WEST SUSSEX COUNTY COUNCIL CONSULTATION

TO:	Arun District Council FAO: Amber Willard
FROM:	WSCC - Highways Authority
DATE:	13 September 2021
LOCATION:	Stakers Farm, North End Road, Yapton, BN18 0DU
SUBJECT:	Y/109/21/HH Upgrading of existing access with new turning area and addition of a garage (This application may affect the Character and Appearance of the Main Road Yapton Conservation Area) (This application may affect the setting of a Listed Building).
DATE OF SITE VISIT:	N/A
RECOMMENDATION:	Advice
S106 CONTRIBUTION TOTAL:	N/A

REV	DESCRIPTION	DATE
PROJECT	STAKERS FARM NORTH END ROAD YAPTON BN18 0DU	
DRAWING TITLE	HOUSE - SITE LOCATION PLAN AND BLOCK PLAN	
SCALE	DRAWN BY	DATE
1:1250 / 1:500 @A3	PLB	JUN 21
DWG NO	1020/10	REV.-

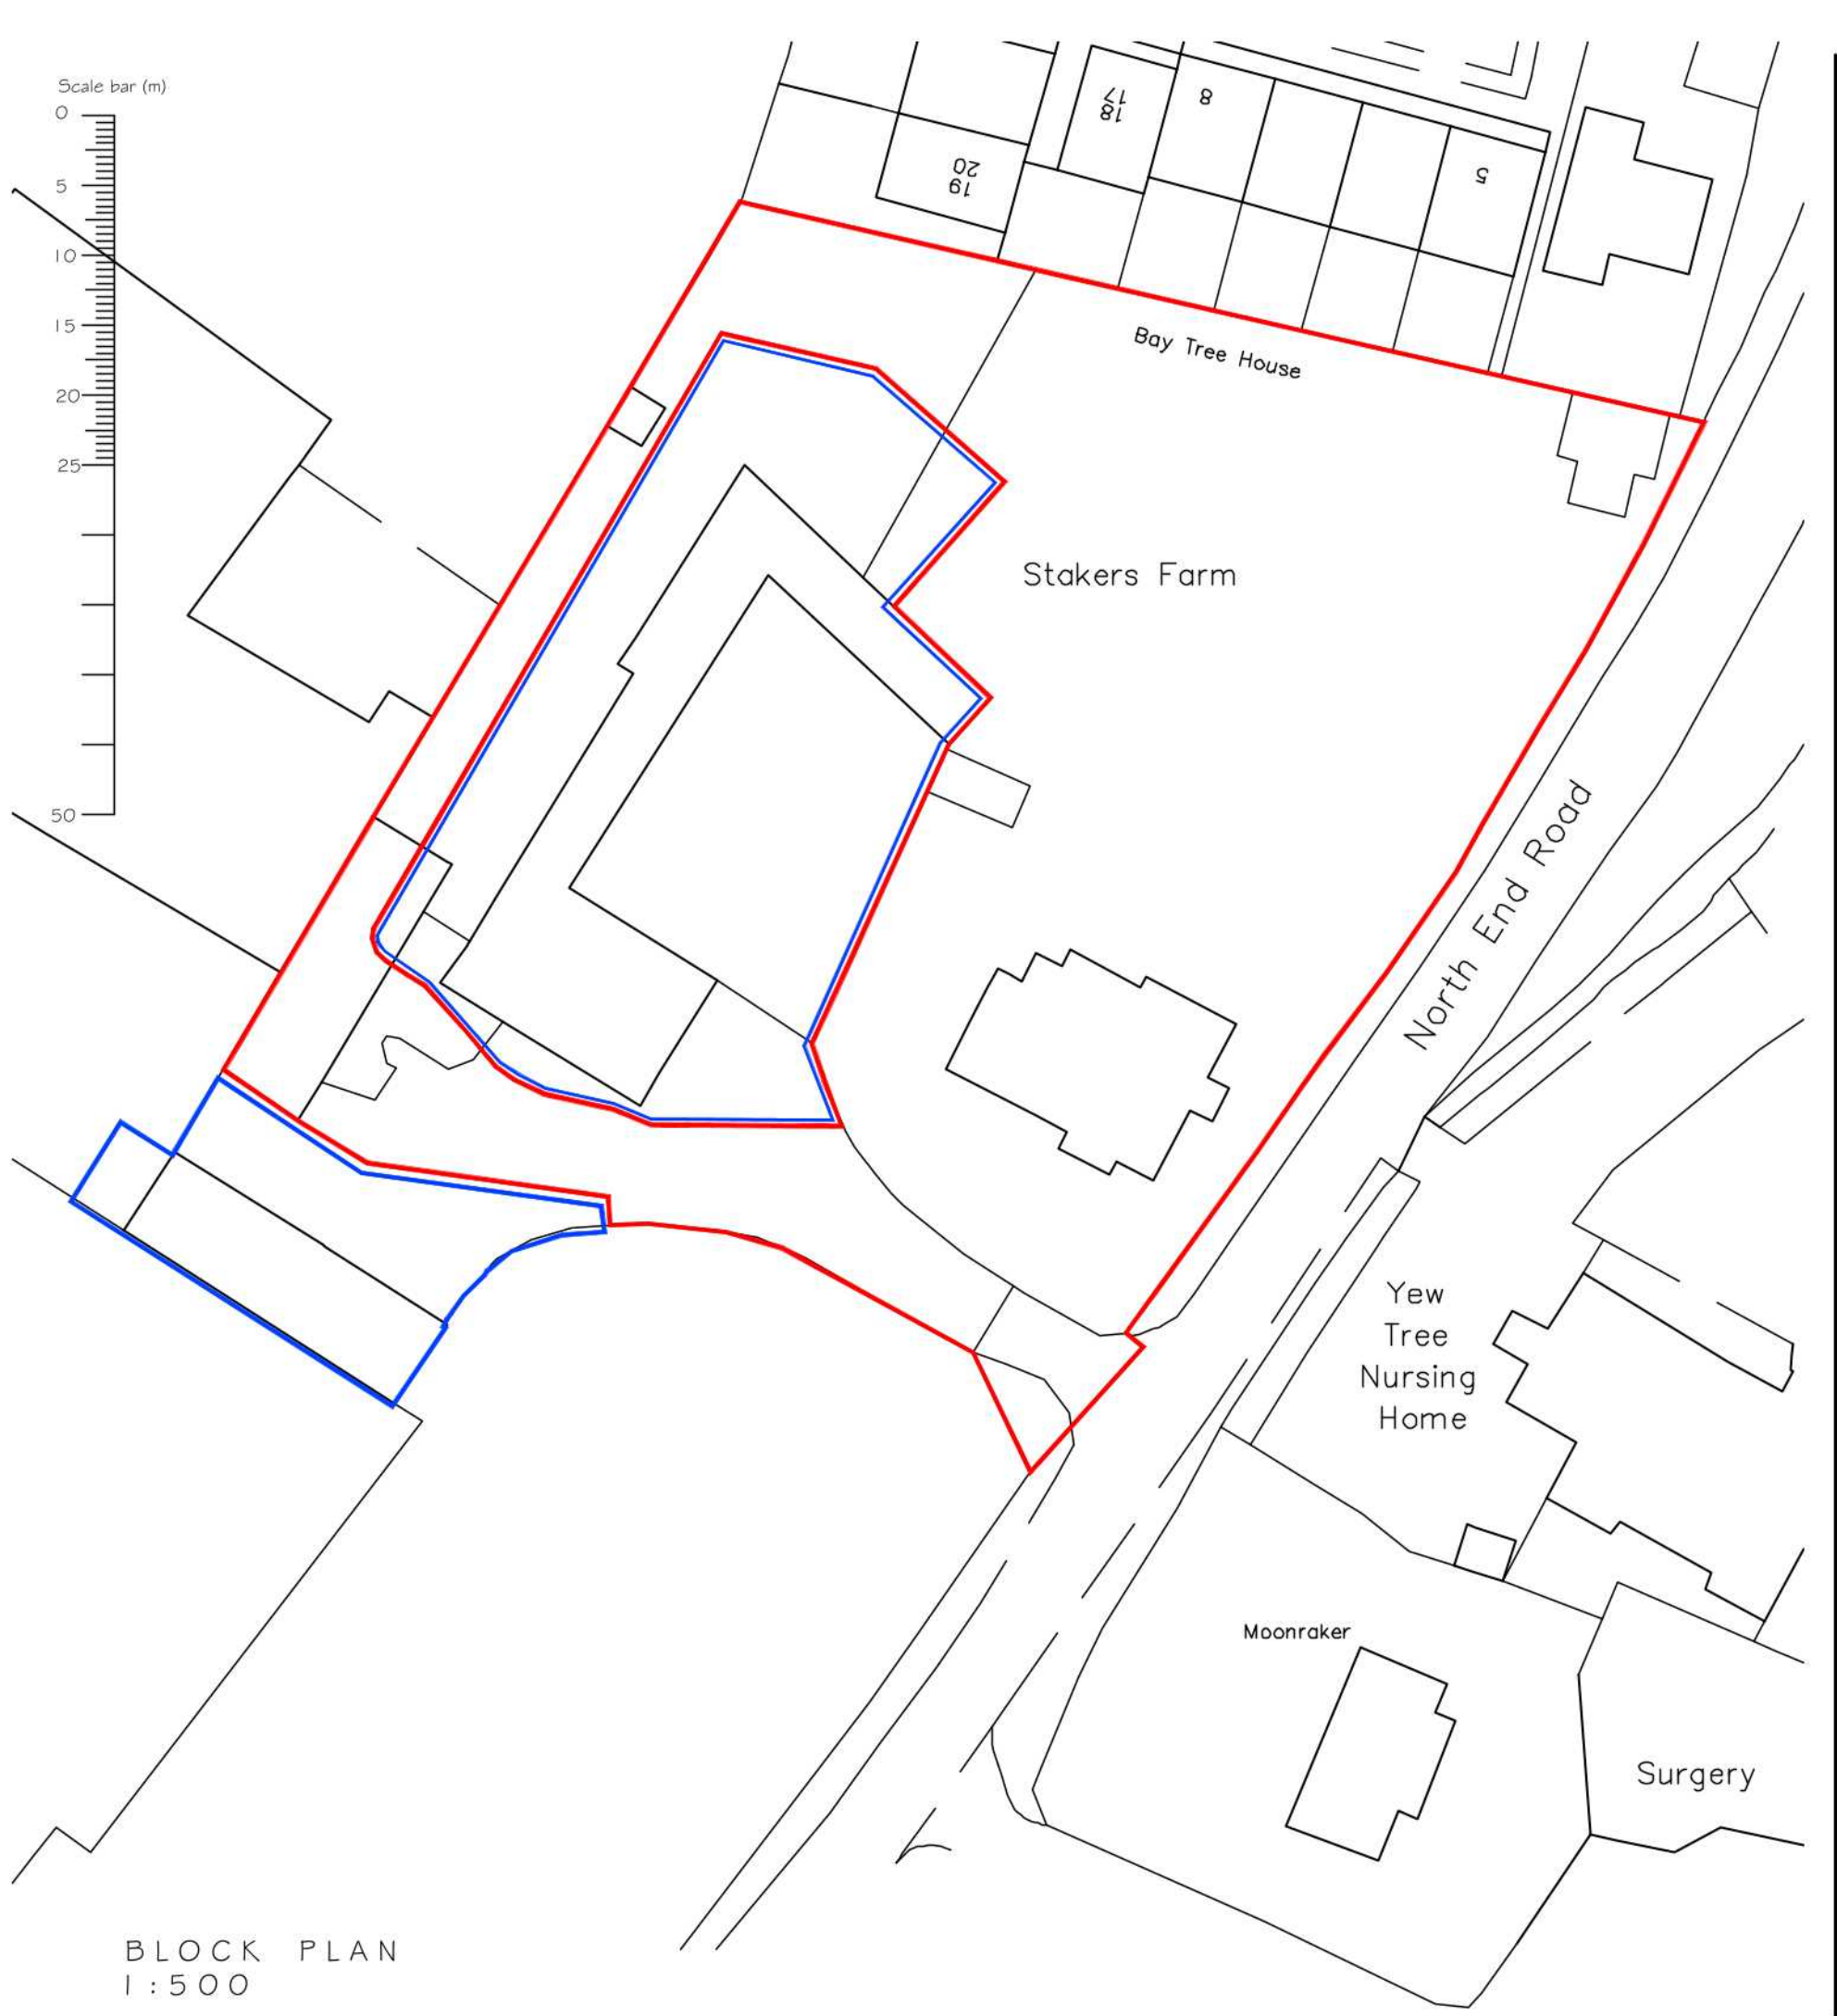
The applicant proposes a 3m wide internal access road. Whilst this road will be too narrow for two cars to pass one another, there is space at either end for a car to wait and allow for another to use the road and pass. In addition, given that this is an internal road serving one site, the chance of vehicular conflict is anticipated to be low.

The applicant has not provided floor plans of the proposed garage building. The garage should be provided in accordance with the specifications set out in Manual for Streets (MfS). For single-bay garages, the internal specifications should be 3m x 6m and double-bay garages should be 6m x 6m. The applicant is requested to demonstrate the proposed garage floor plans in accordance with MfS specifications.

Notwithstanding the above, the LHA does not anticipate that the proposals would give rise to a material intensification of movements to or from the site. The provision of a turning area will allow for cars to turn on-site and exit on to the maintained highway in a forward gear.

No part of the development shall be first occupied until the car parking spaces have been constructed in accordance with plans and details to be submitted to and approved in writing by the Local Planning Authority. These spaces shall thereafter be retained at all times for their designated purpose.
